## *Rezoning Petition Review*

**Rezoning Petition #:** 08-128

**Location of Property:** Approximately 2.50 acres located on the west side of Statesville Rd between Twin Lakes Parkway and Future I-485

C1.0

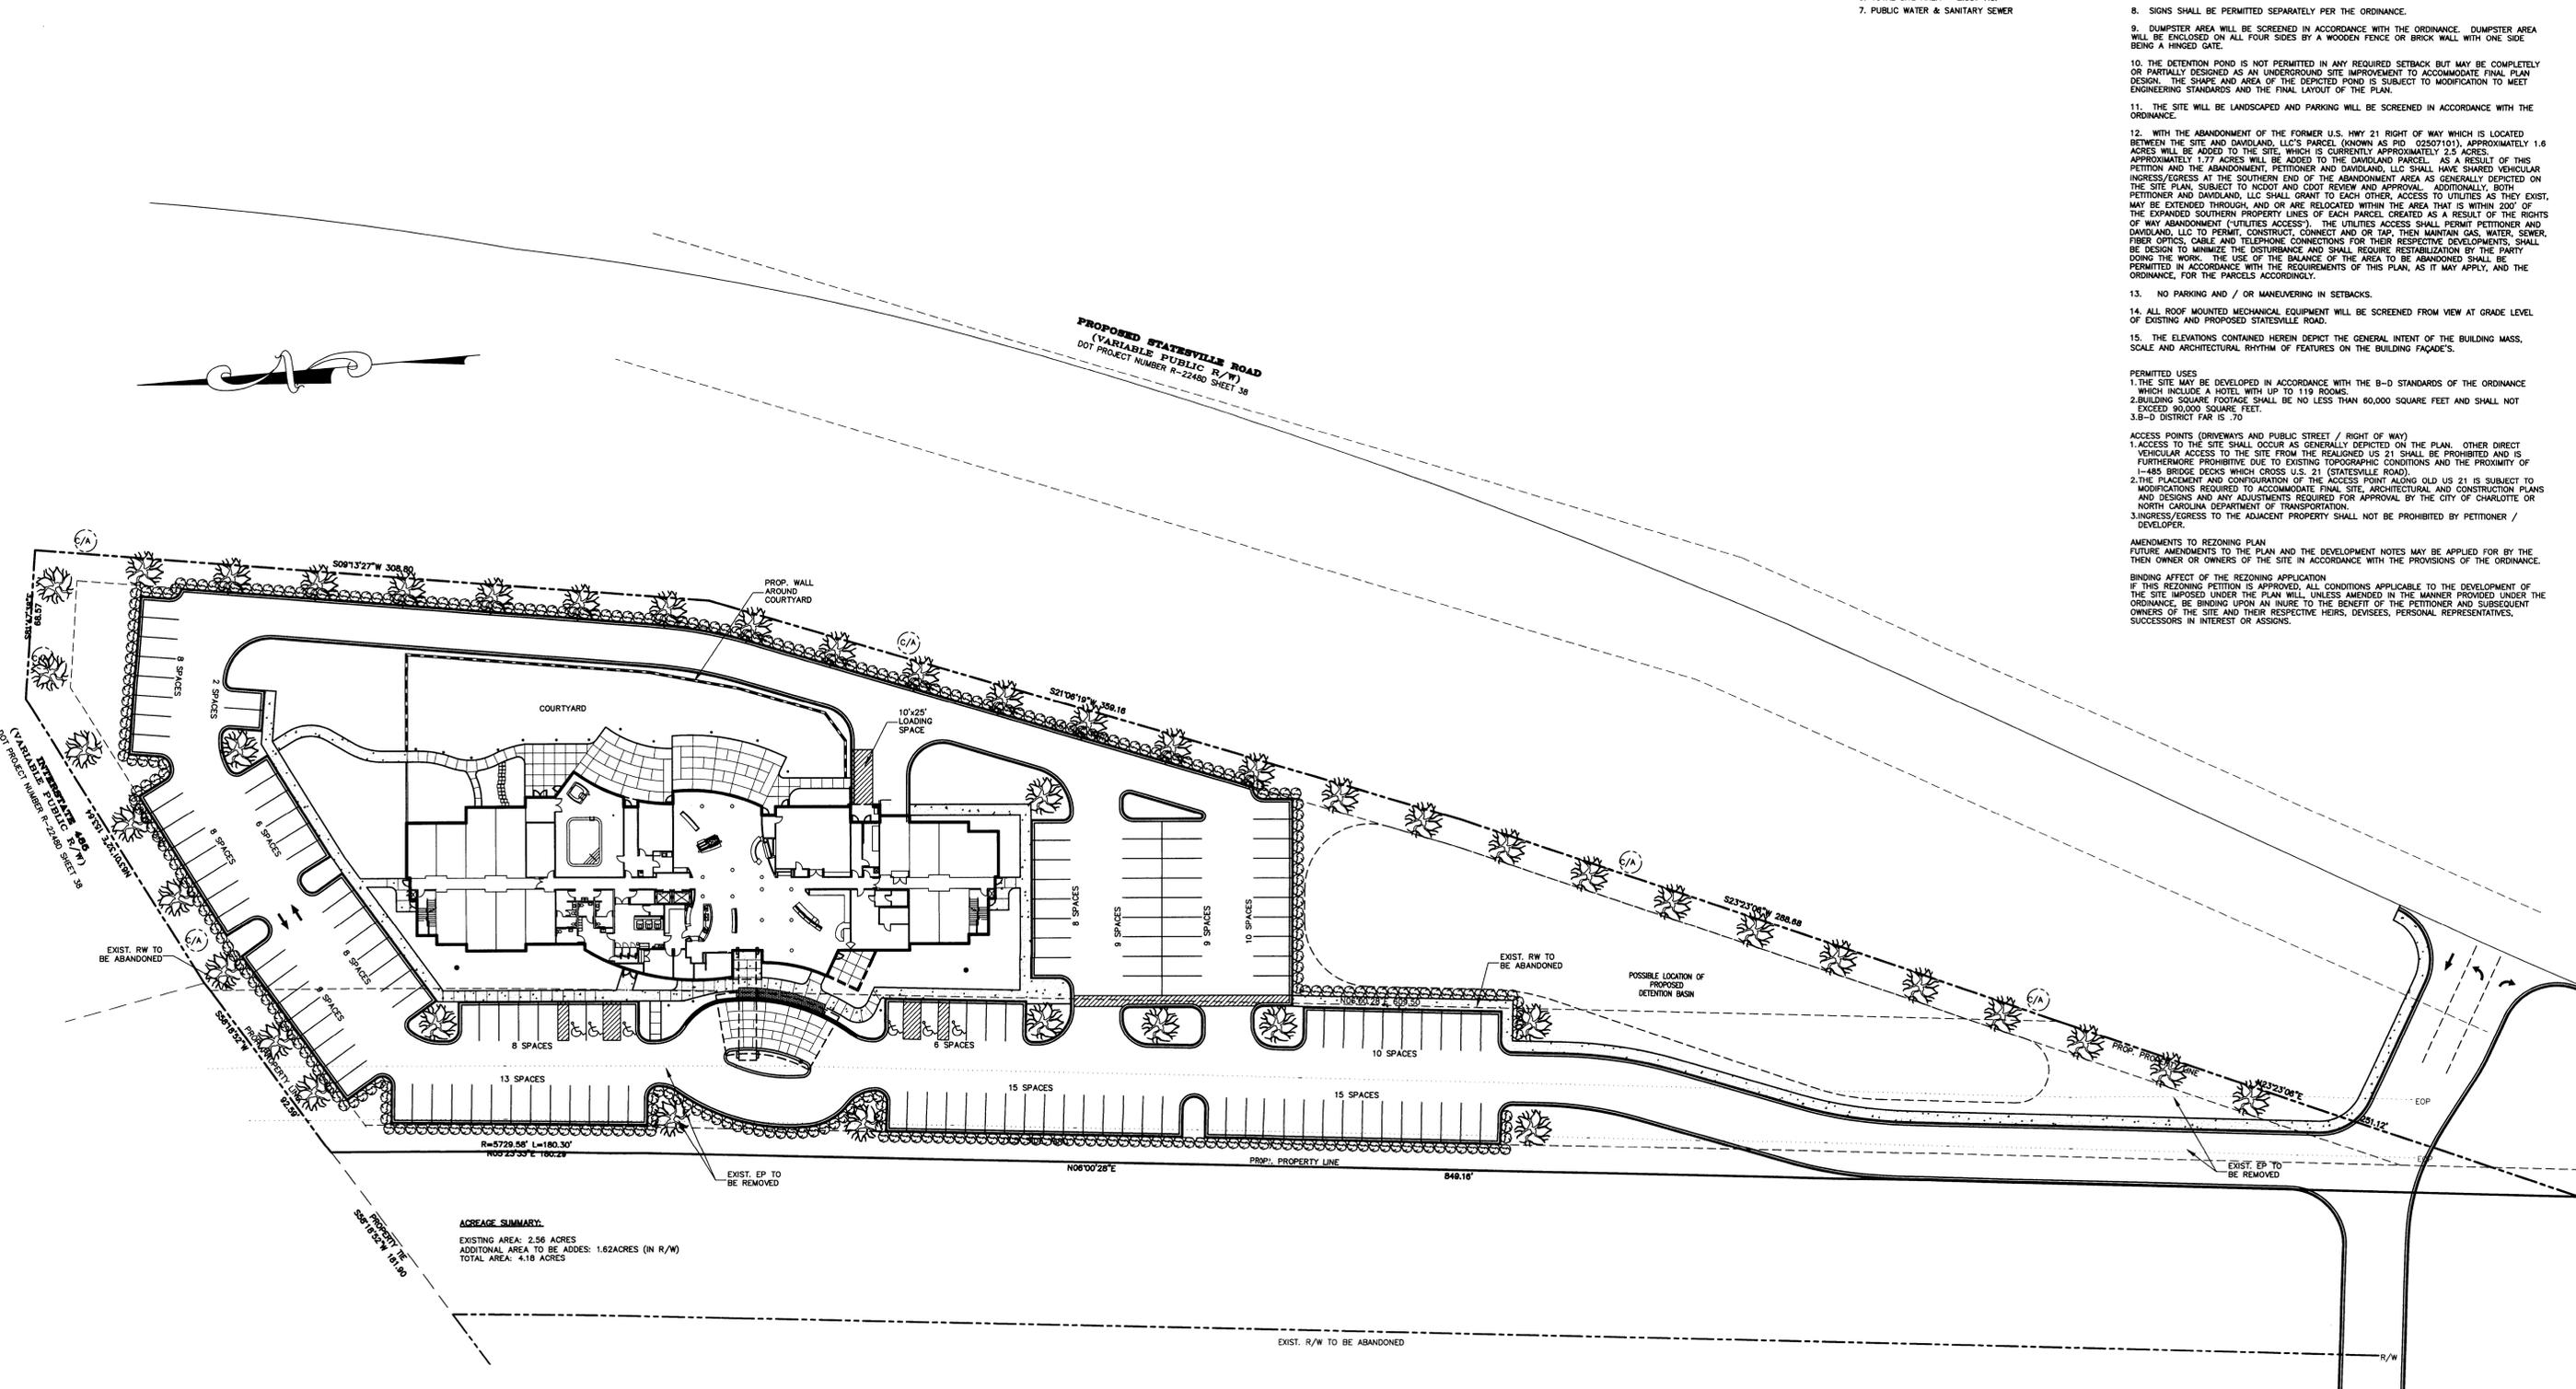
**Recommendations Concerning Storm Water:** **Please remove Notes 5, 6, 7 & 8 under General Provisions and replace with the following note**

The petitioner shall comply with the Charlotte City Council approved and adopted Post Construction Controls Ordinance.
